M54- M6 Toll Link Road

Planning Inspectorate Reference: TR010054:

**Summary of Natural England's written representations**

3 November 2020

40-44 µg/m<sup>3</sup>

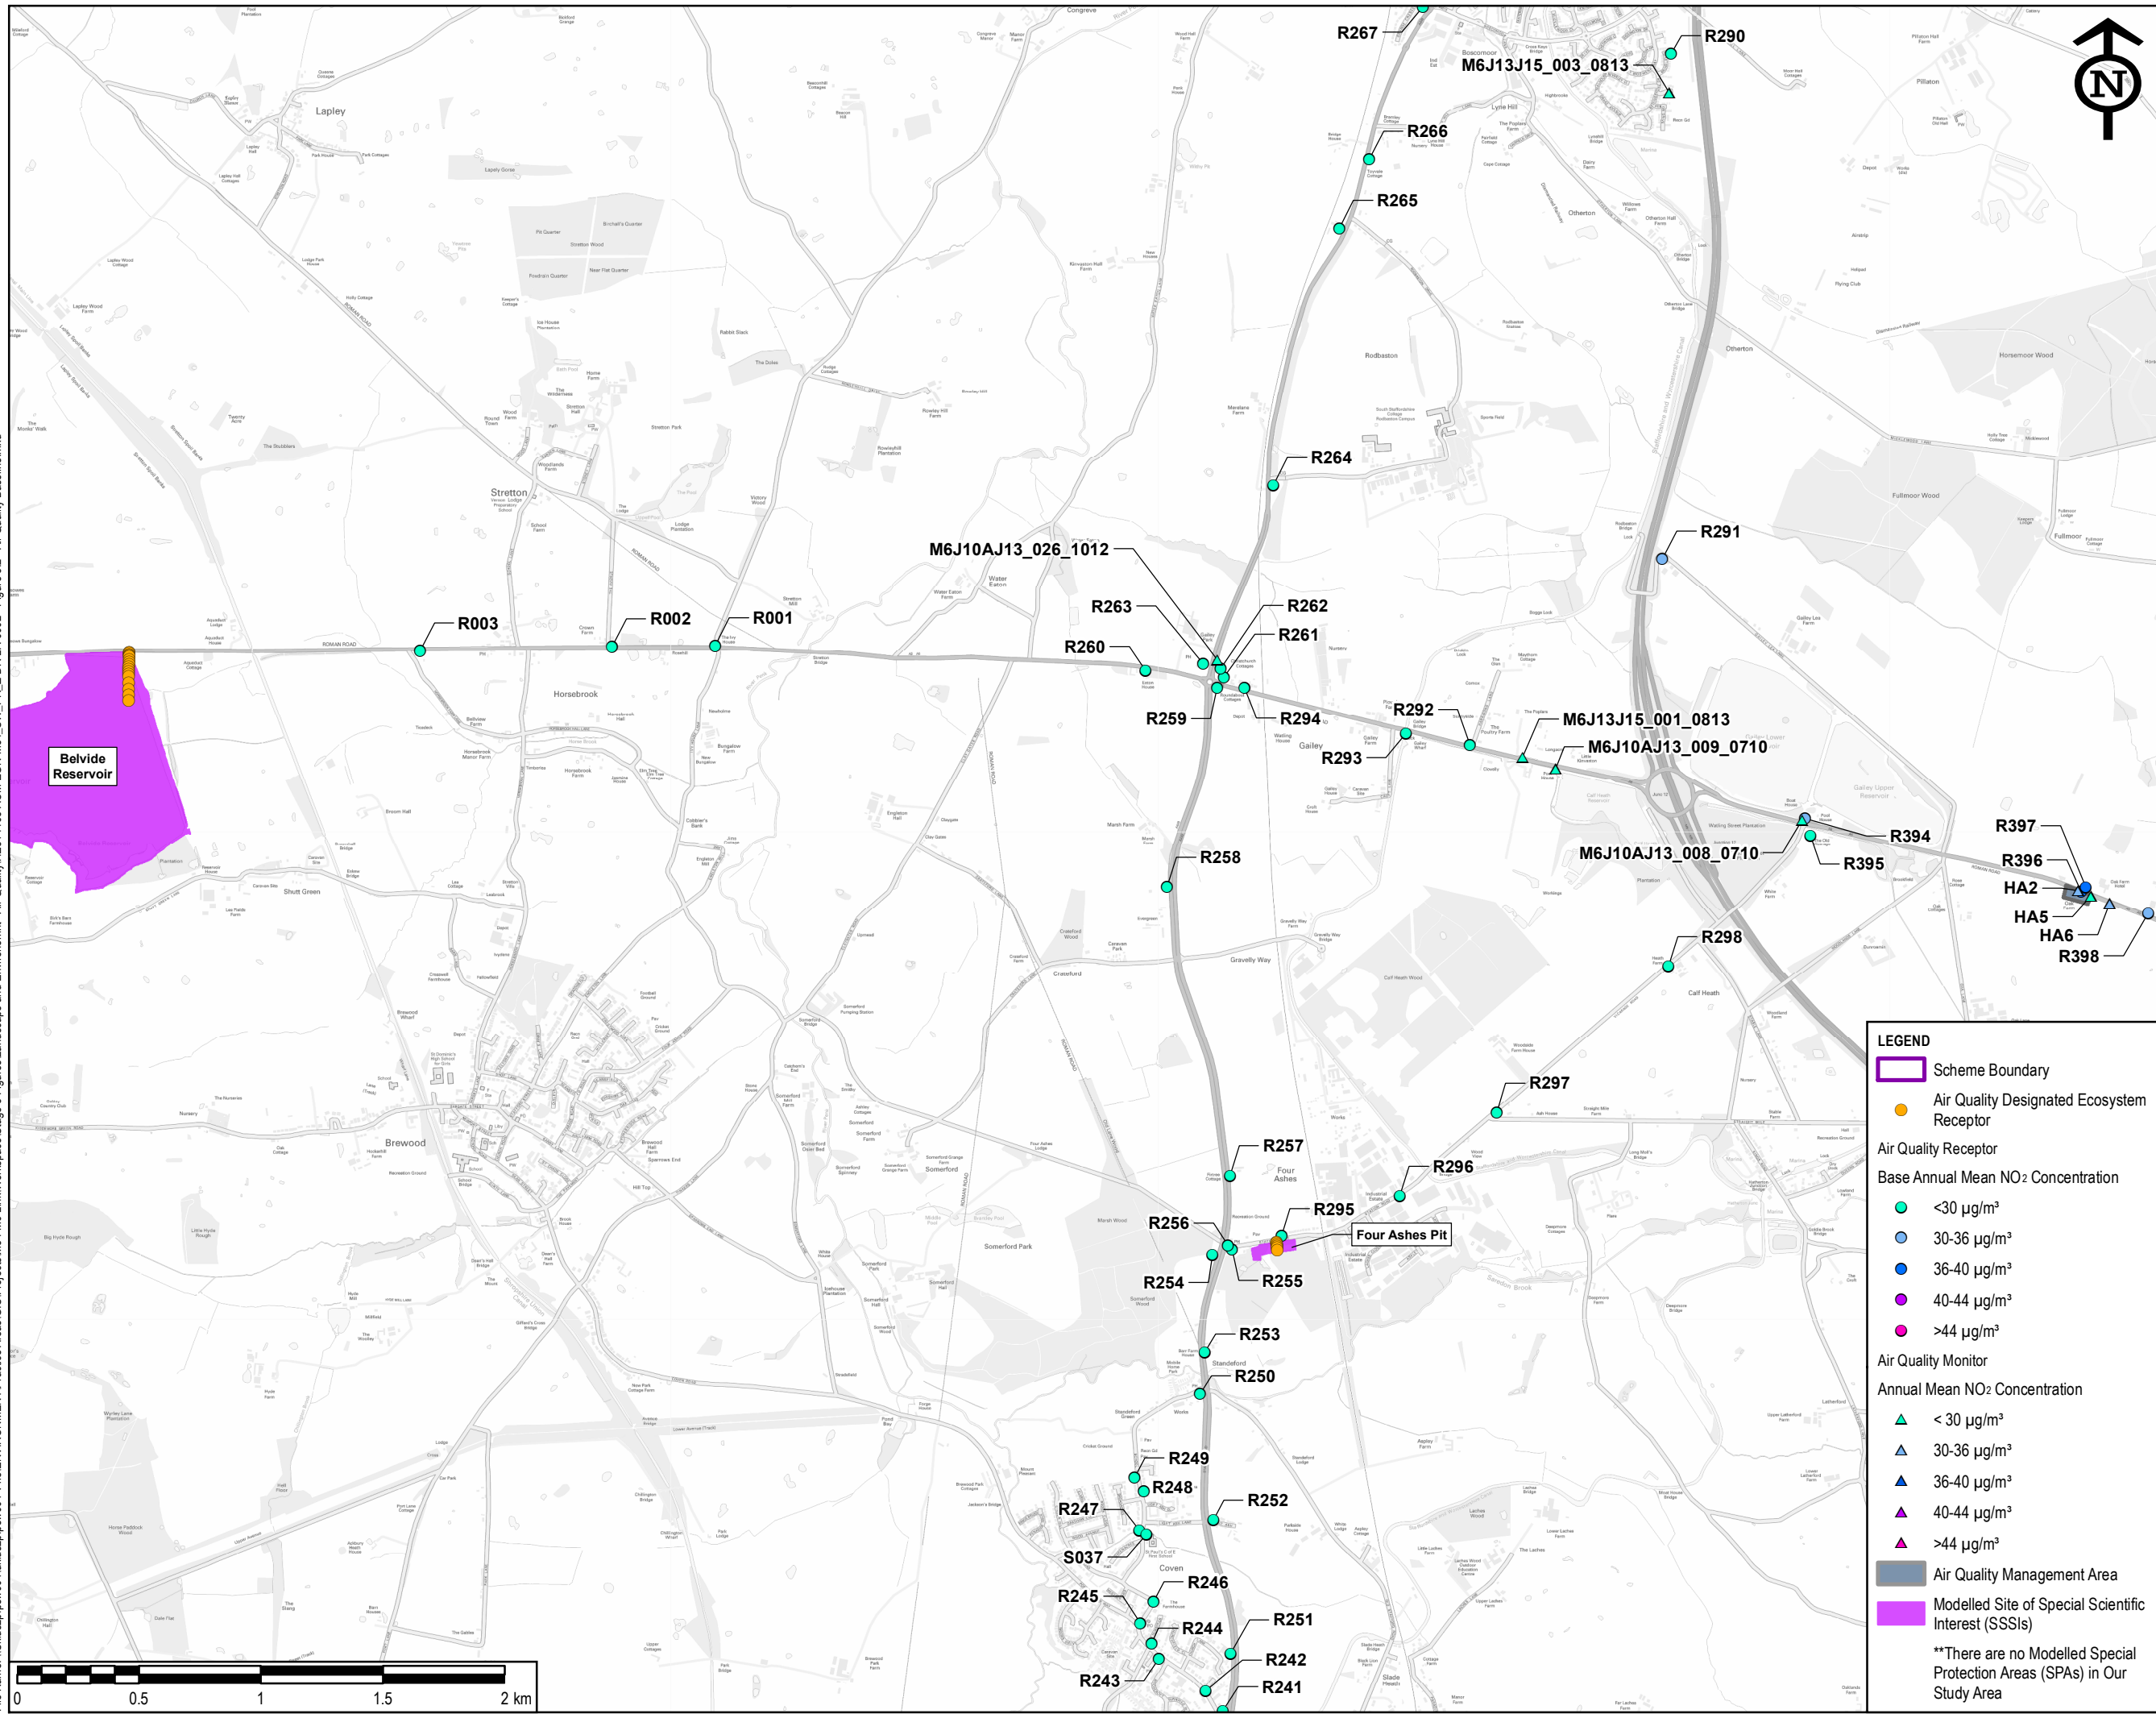
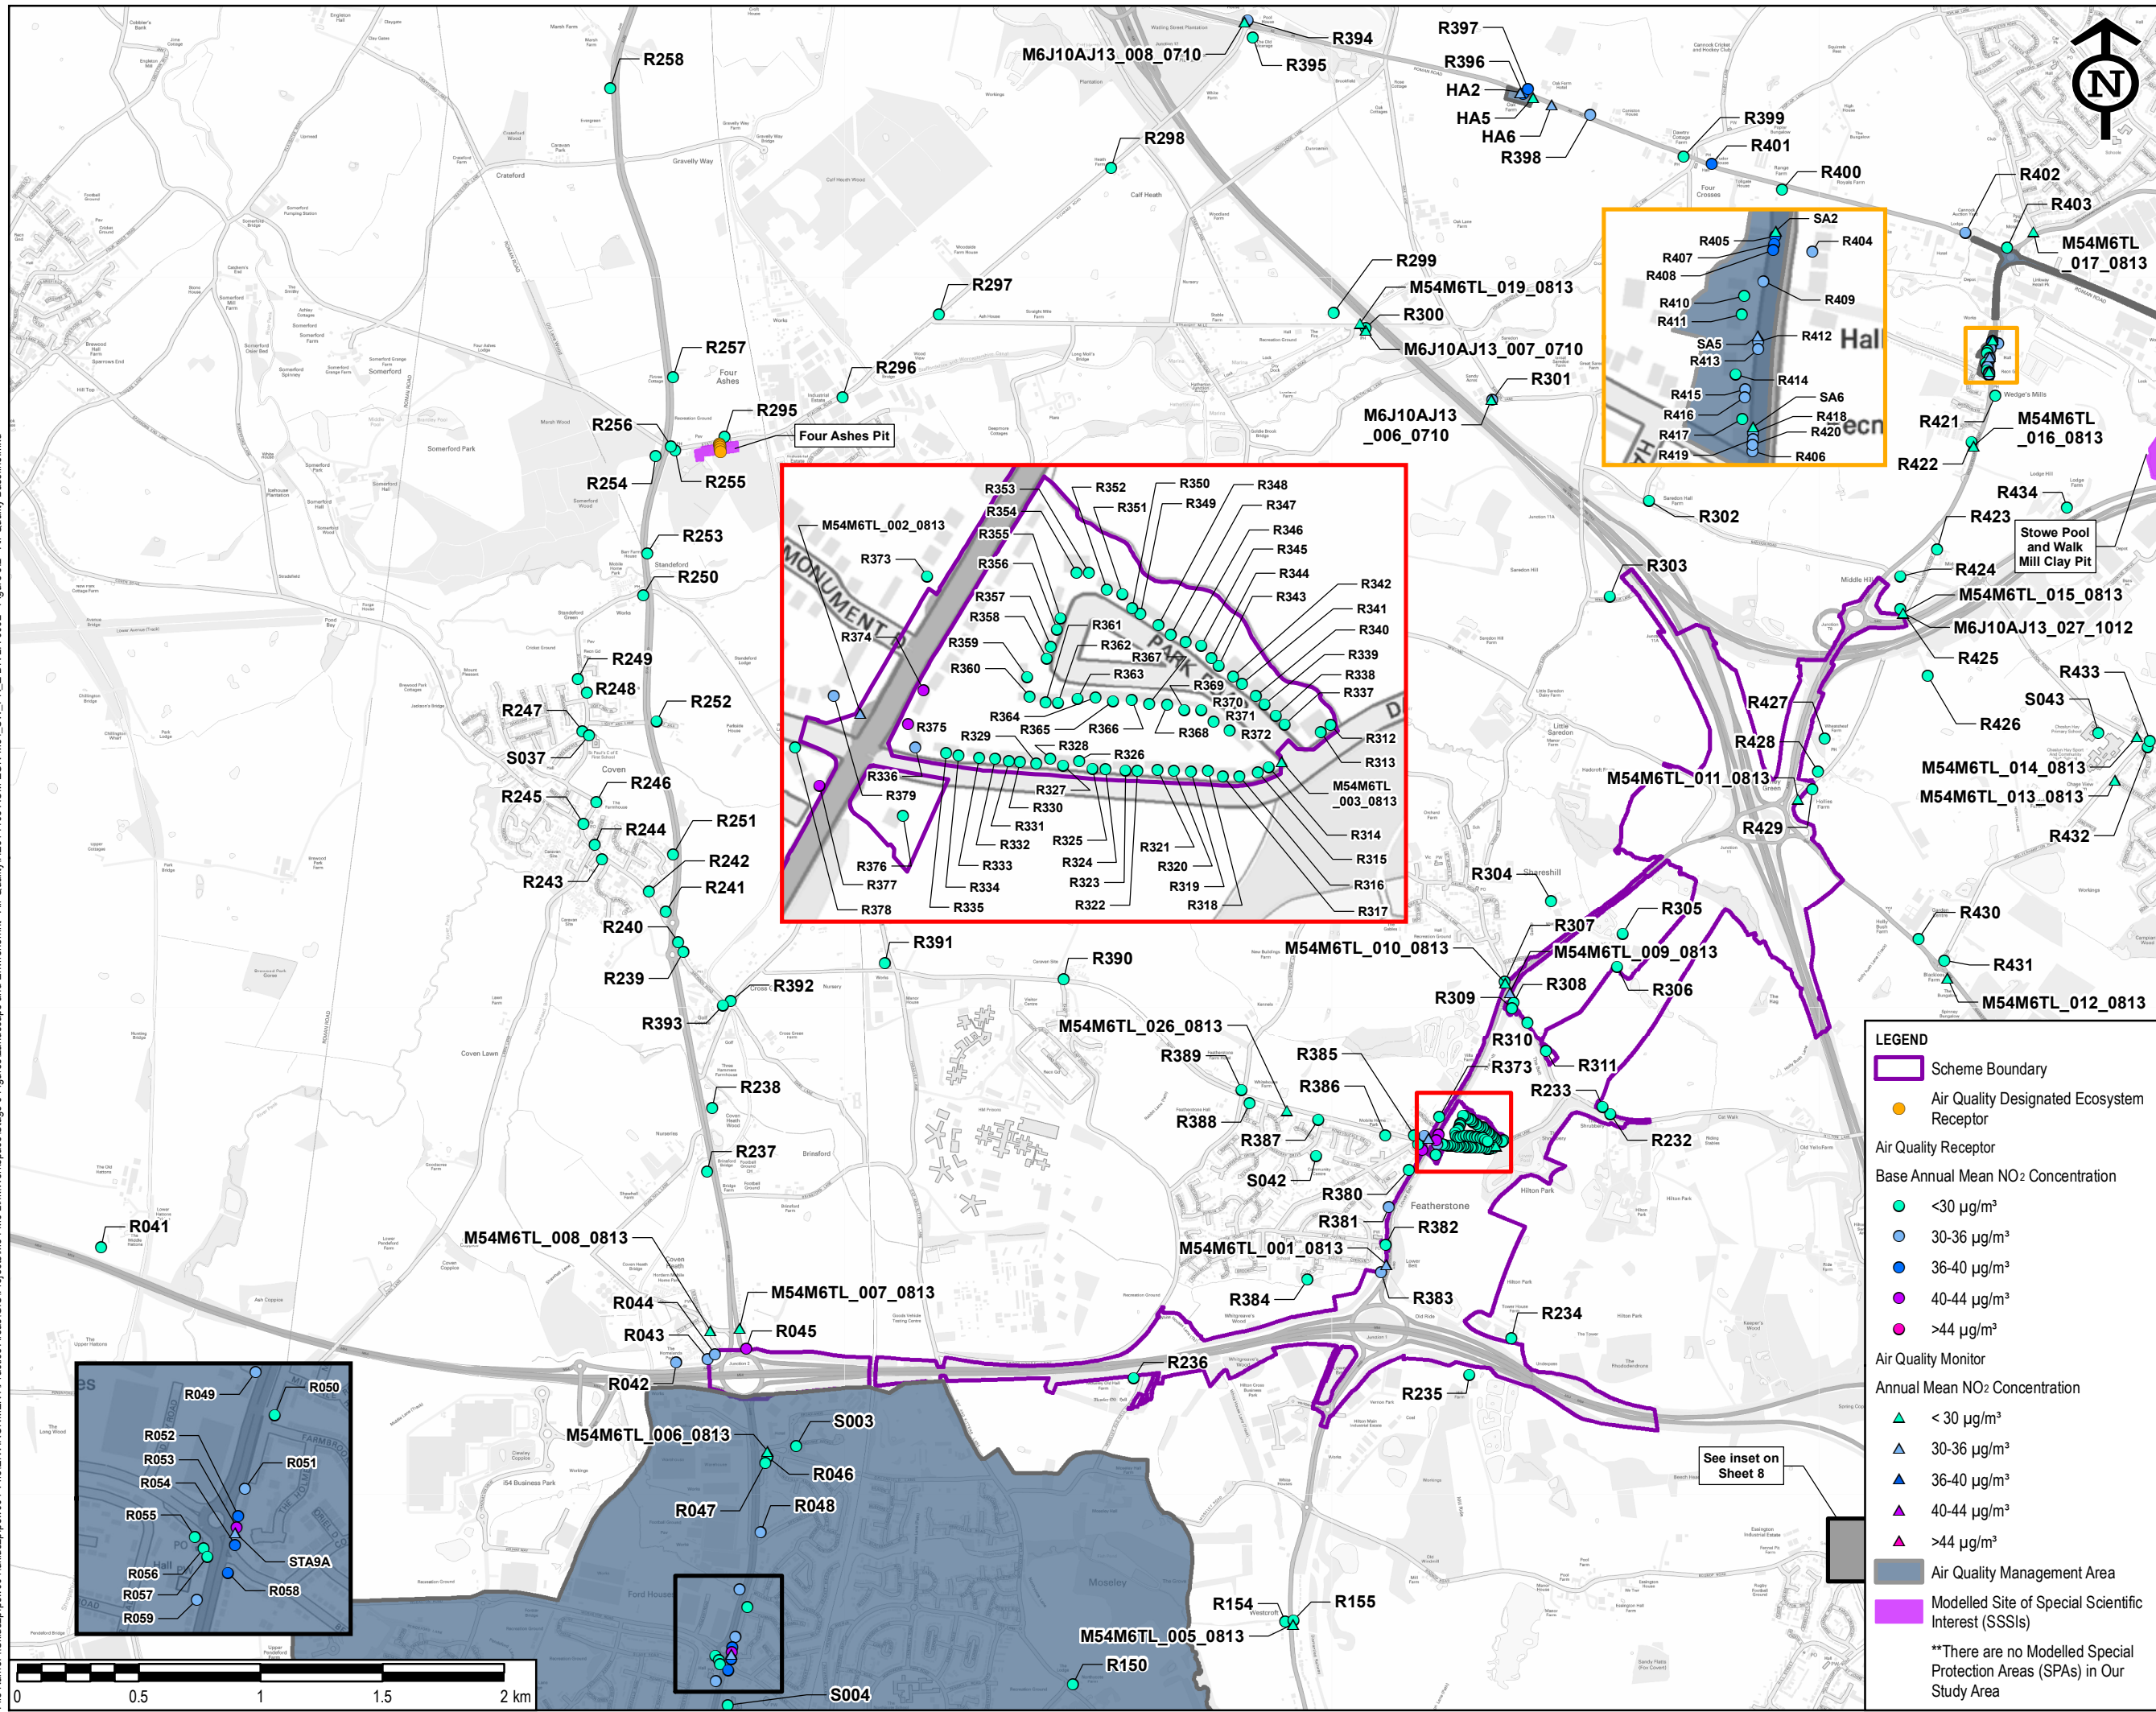
- Confirmation that example sites have been screened out.
      - Indirect impacts require consideration. Cannock Extension Canal SAC is hydrologically linked to Chasewater and Southern Staffordshire Coalfield Heath SSSI, which will be affected by nitrogen deposition.

- 3.2. Nationally designated sites
    - Chasewater and the southern Staffordshire Coalfield Heaths SSSI
    - Stowe Pool and Walkmill Claypit SSSI
      - The scheme would result in increases in NOx and nitrogen deposition at these sites further discussions are required over the assessment and conclusions with regards to potential impacts of these increases (alone and cumulatively) and mitigation.

- Where there is unavoidable loss of ancient woodland the Applicant and Natural England have agreed a ratio of replacement planting and improvement works to Oxden Leasow Wood (also known as Whitgreaves Wood). The detail of the compensation measures requires further discussion.
- Increases in nitrogen deposition on Oxden Leasow Wood and woodland at Brookfield Farm require further discussion on potential impacts on impacts alone and cumulatively.
